Date: 5 November 2025

BEACON FEN ENERGY PARK

PROPOSED BEACON FEN ENERGY PARK (APPLICATION REFERENCE: EN010151) NOTIFICATION OF PROPOSED CHANGE TO THE DCO APPLICATION

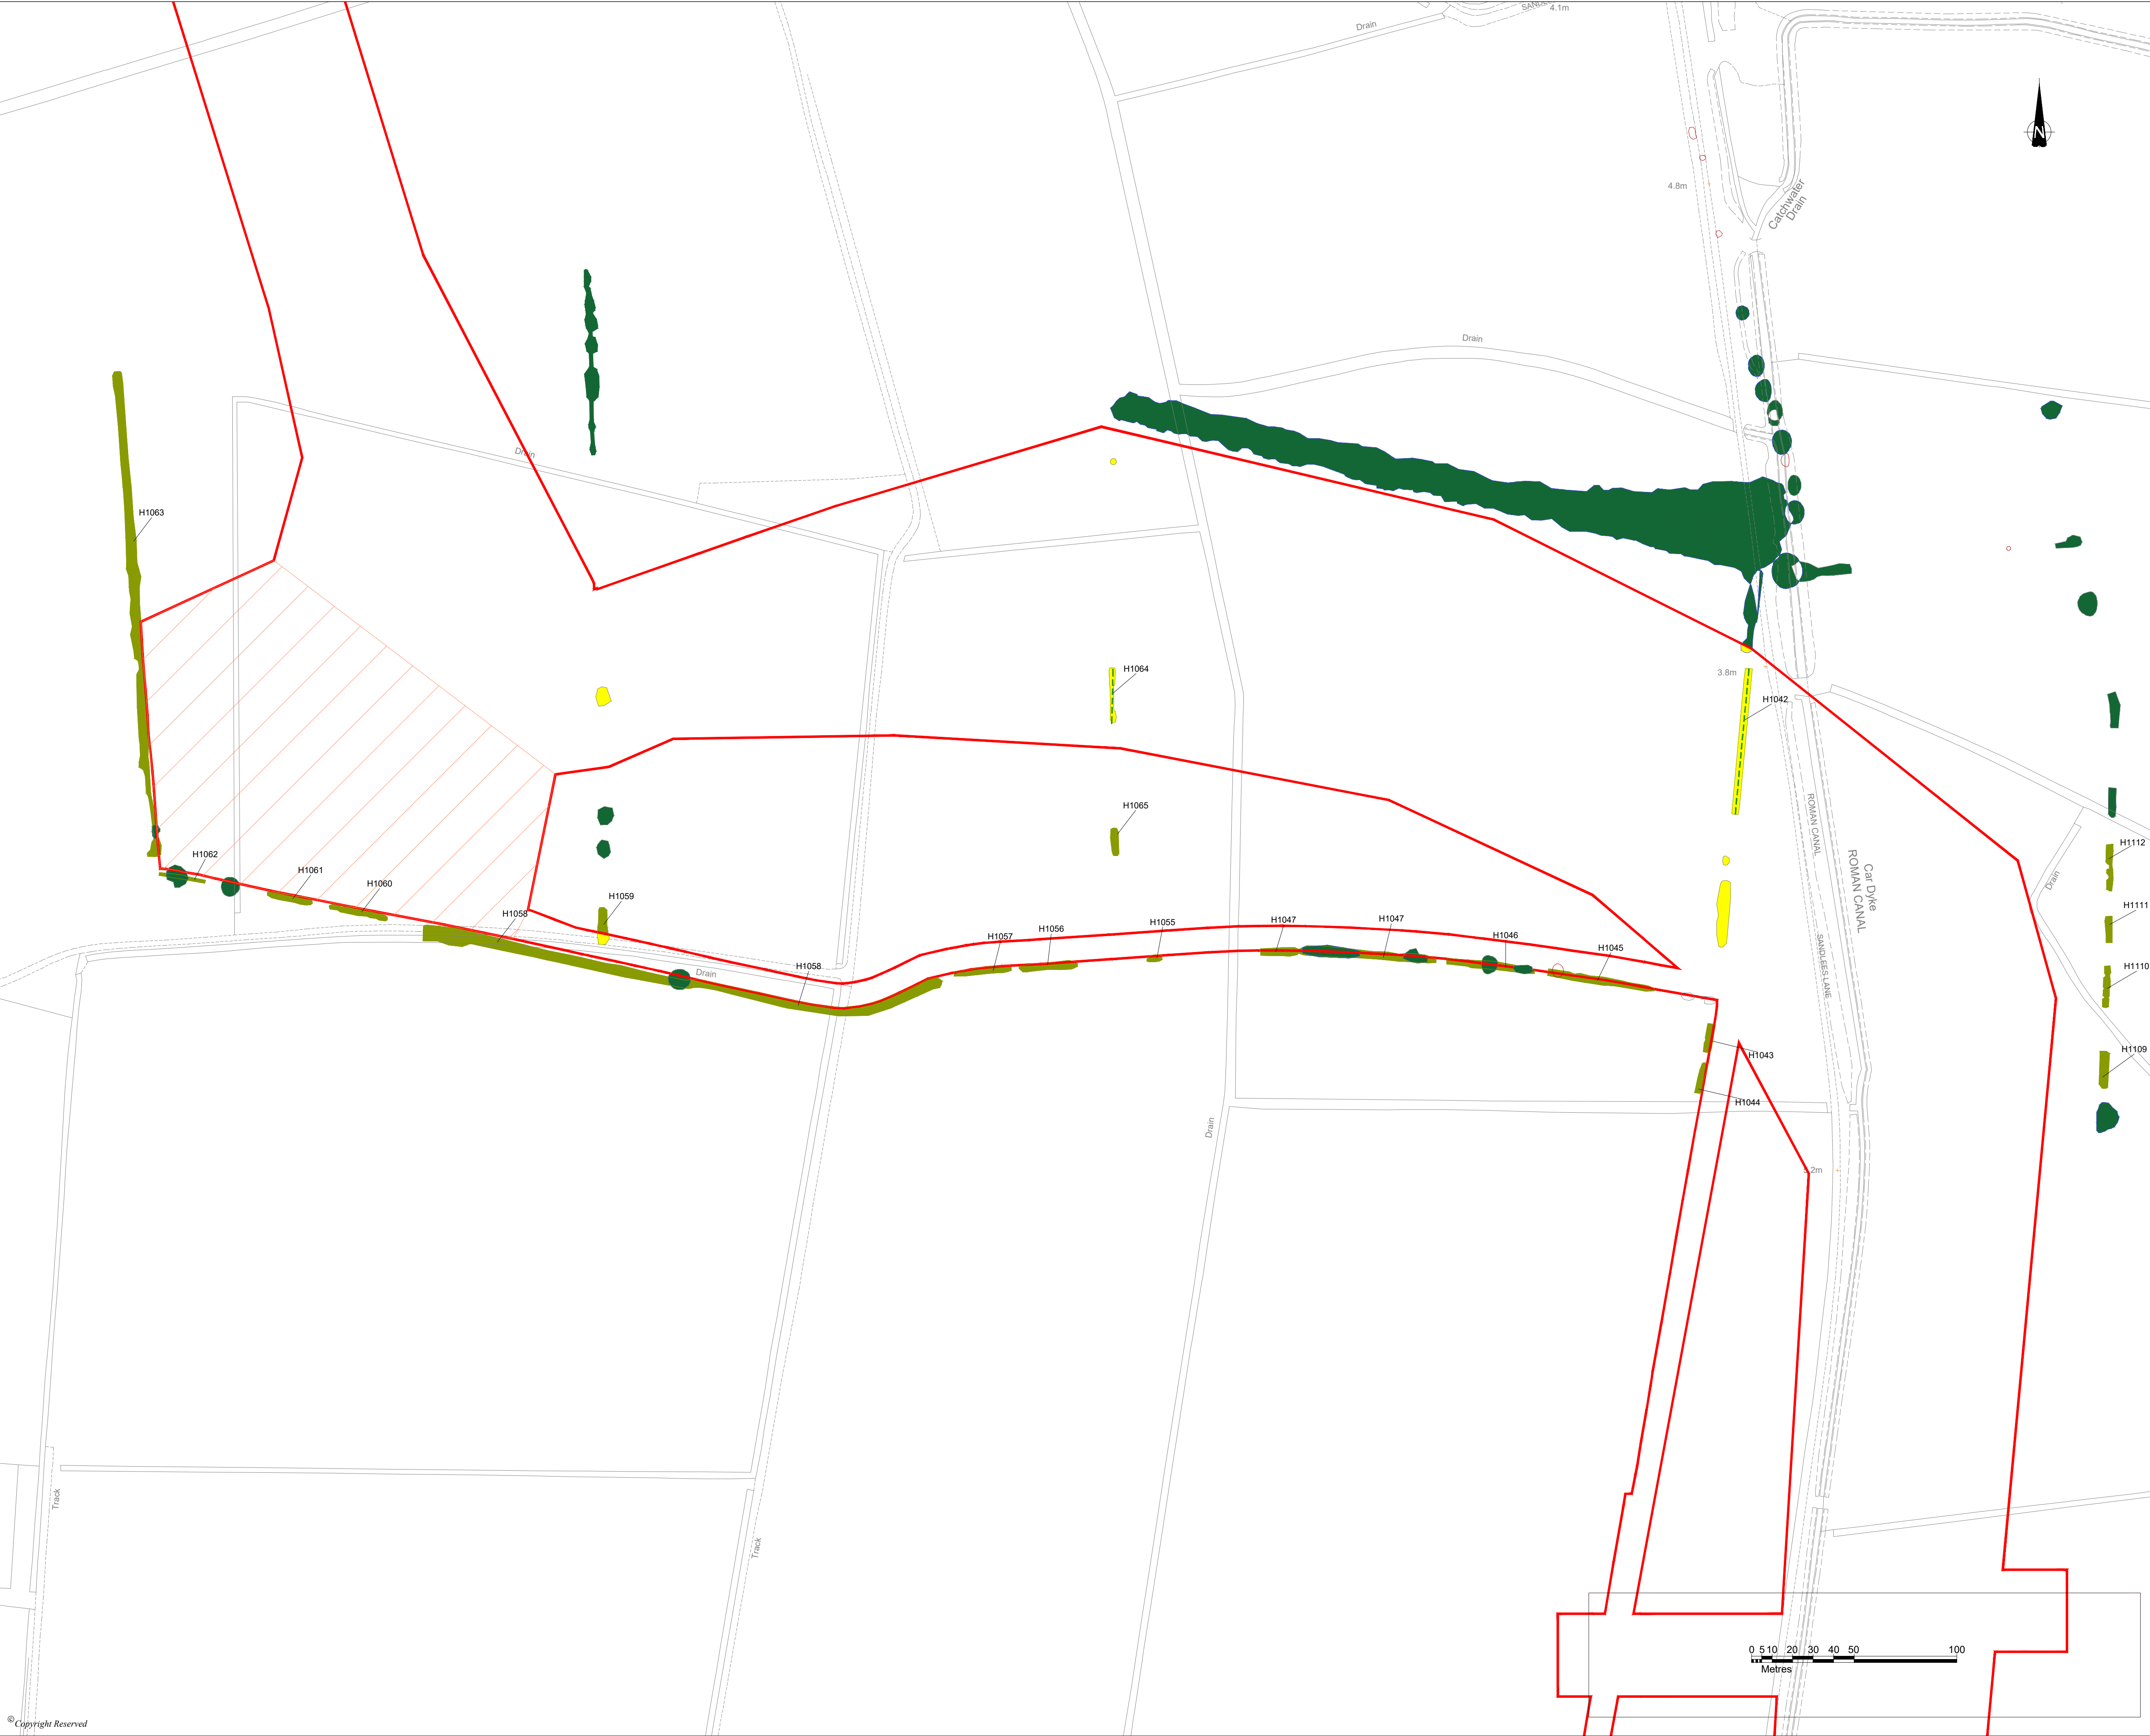
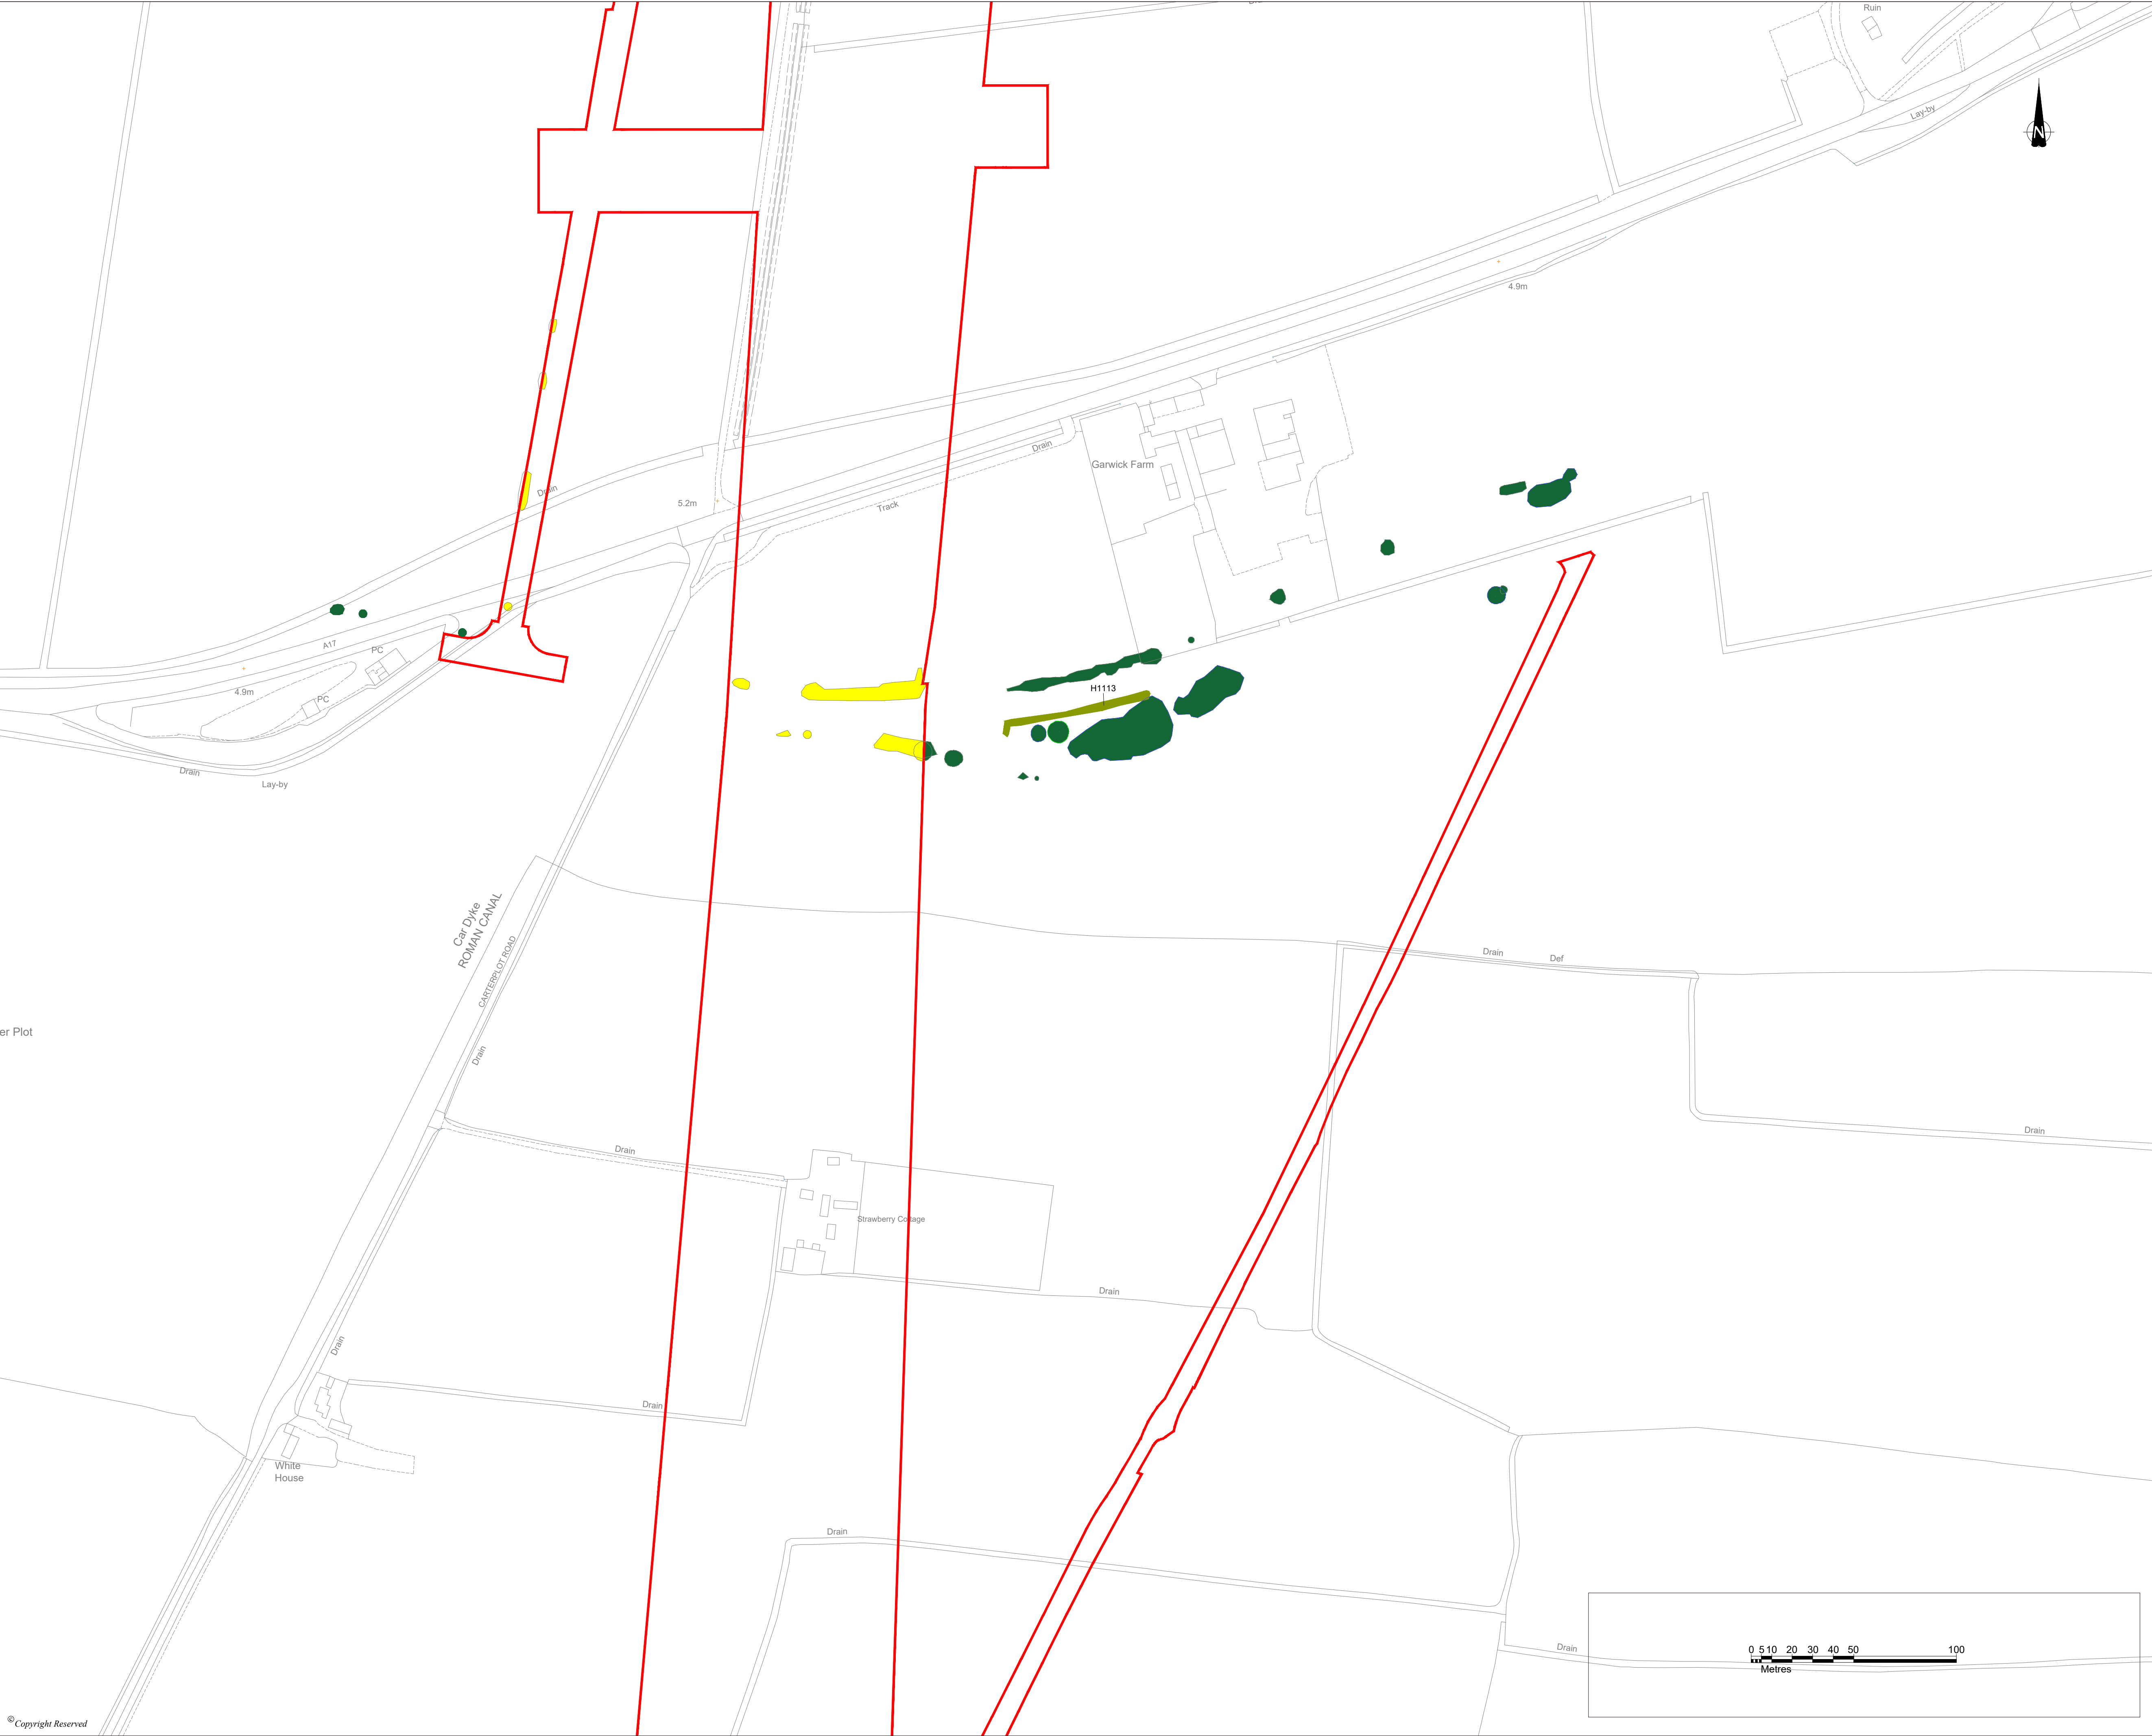
- Extension of the temporary laydown (Work No. 5D) to an area that is largely existing hardstanding adjacent to the south; and
- Vegetation removal and infilling of the existing drainage pond adjacent the Substation to construct the Substation extension works (Work No. 5E);
